Project Submittal Interim Form

Project Name: * R-5709. Widening of NC 211 in Moore & Hoke Counties

R-5709 Revised Permit Drawings 02282024p.pdf 9.02MB

SAW-2018-02283

SITE 2

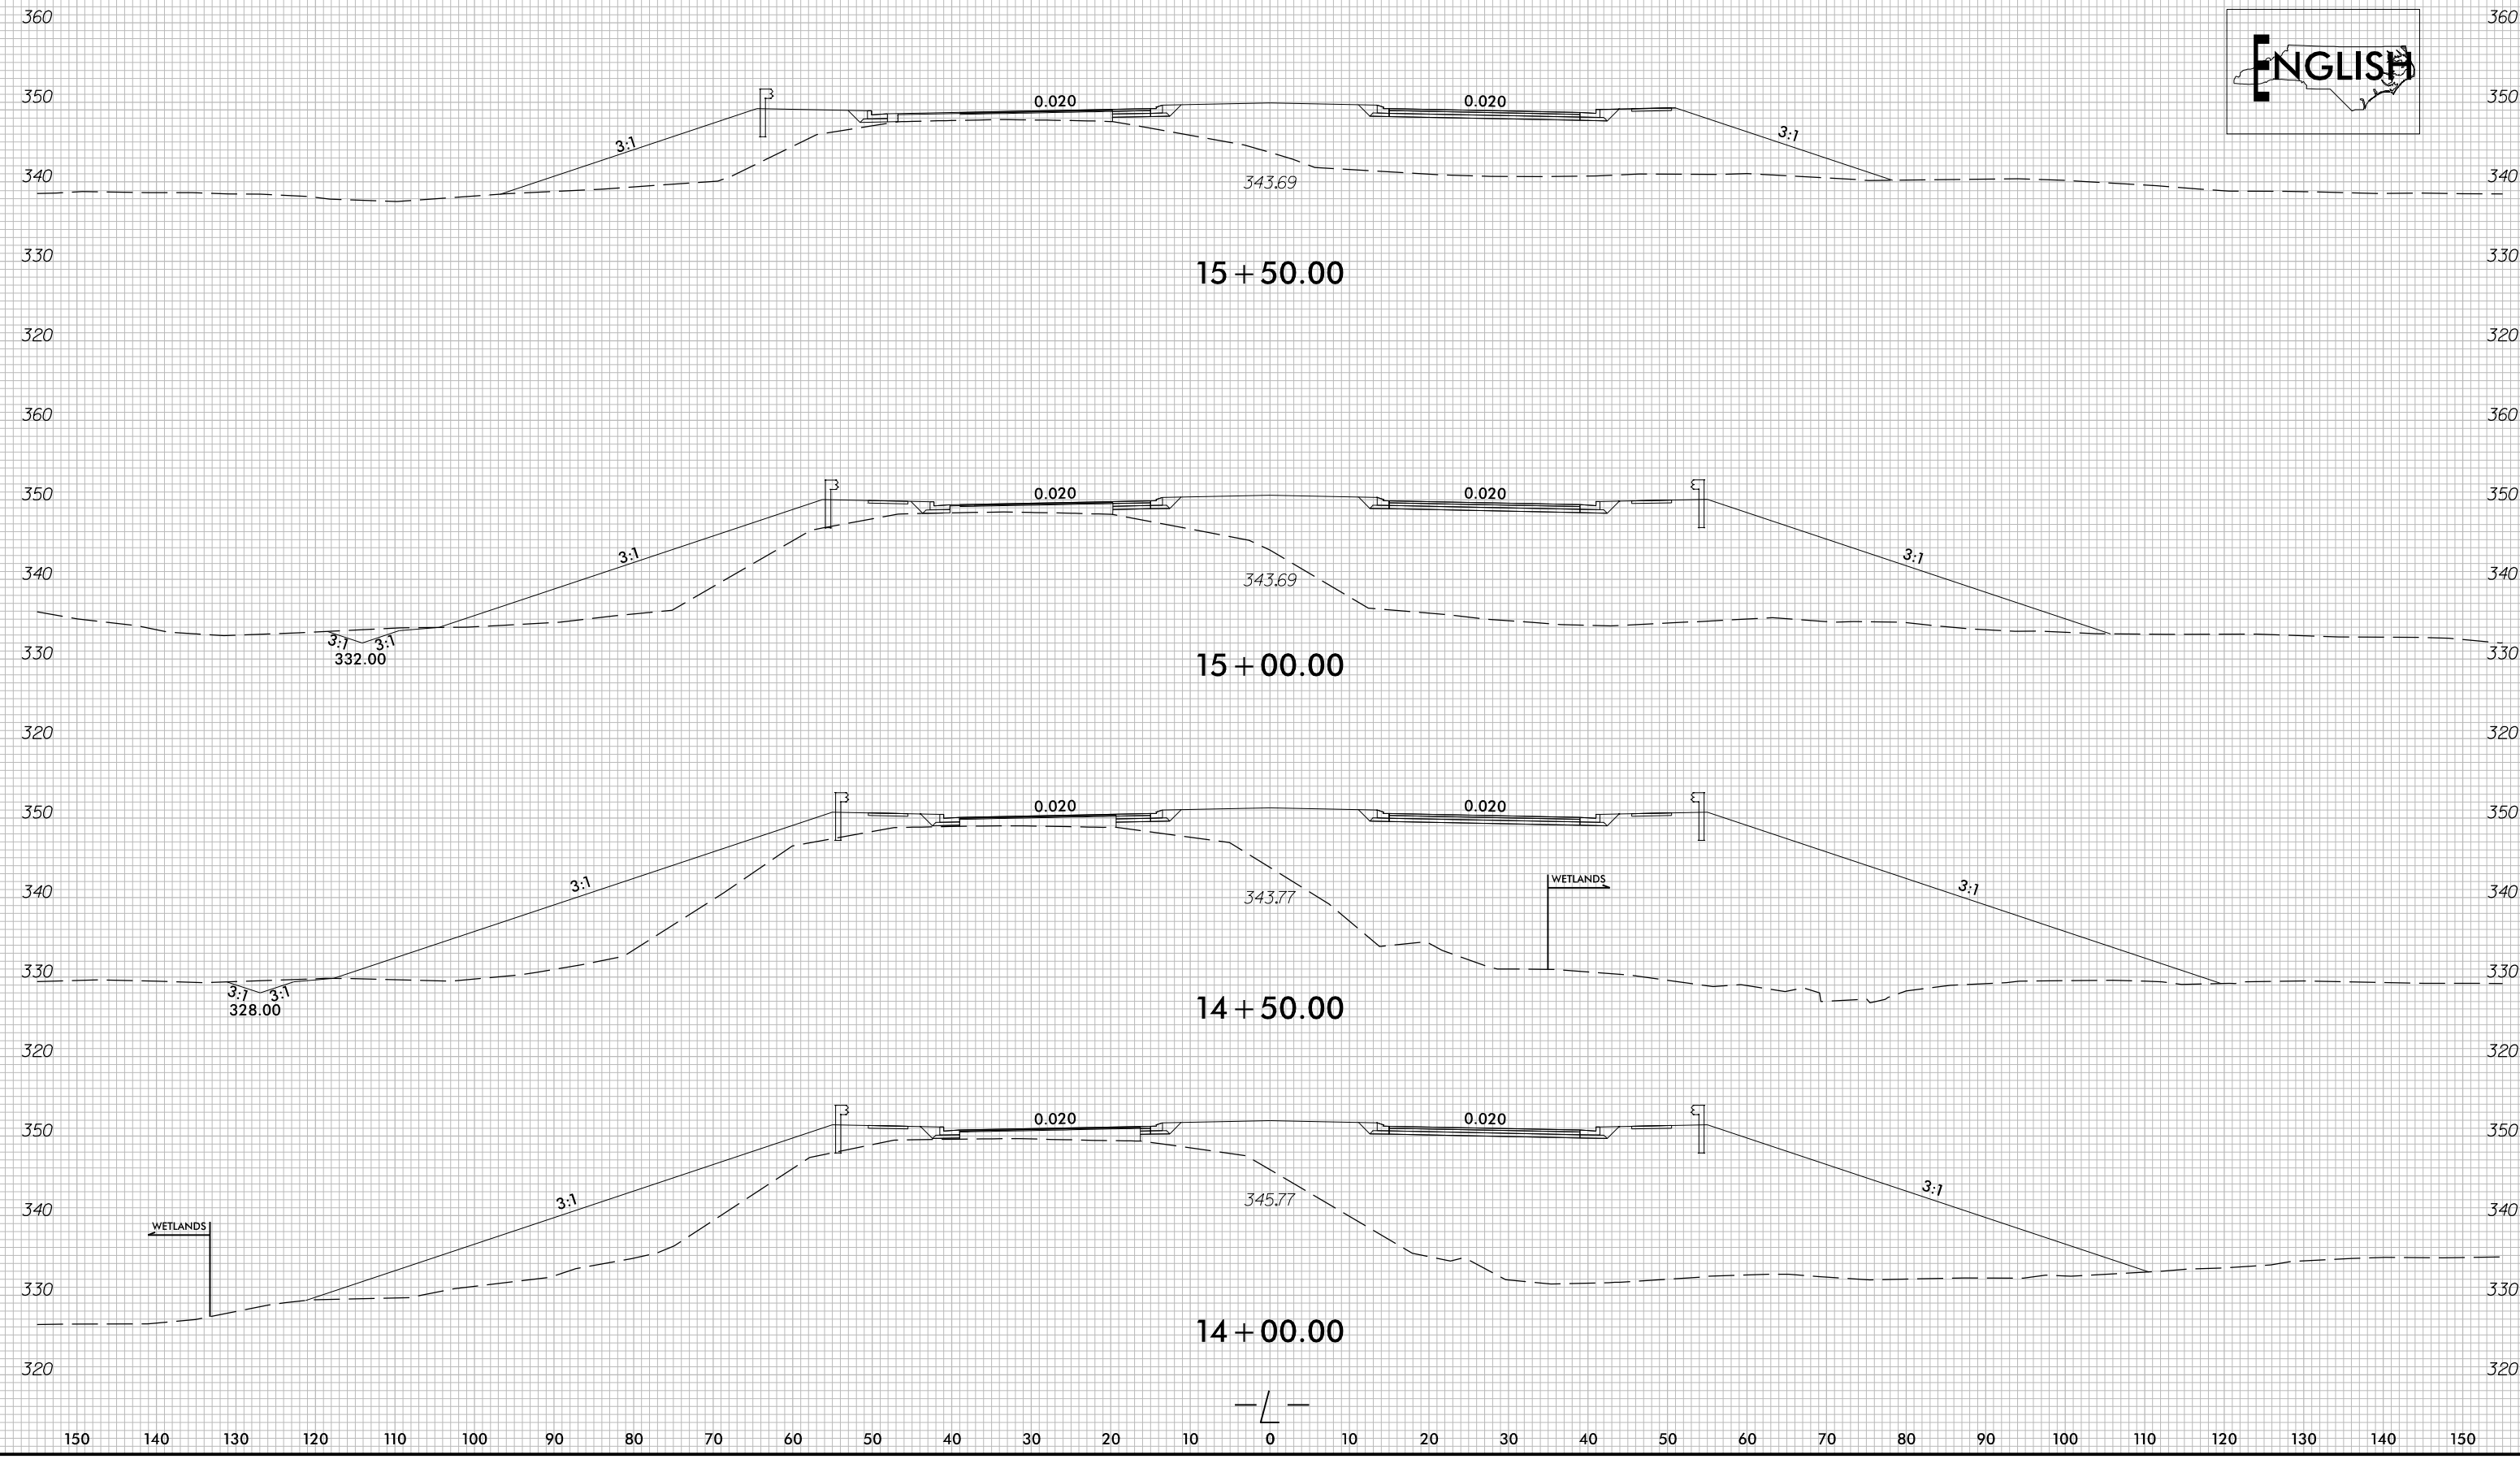
Site 2: Hand clearing increased to reflect the accurate amount at this site.
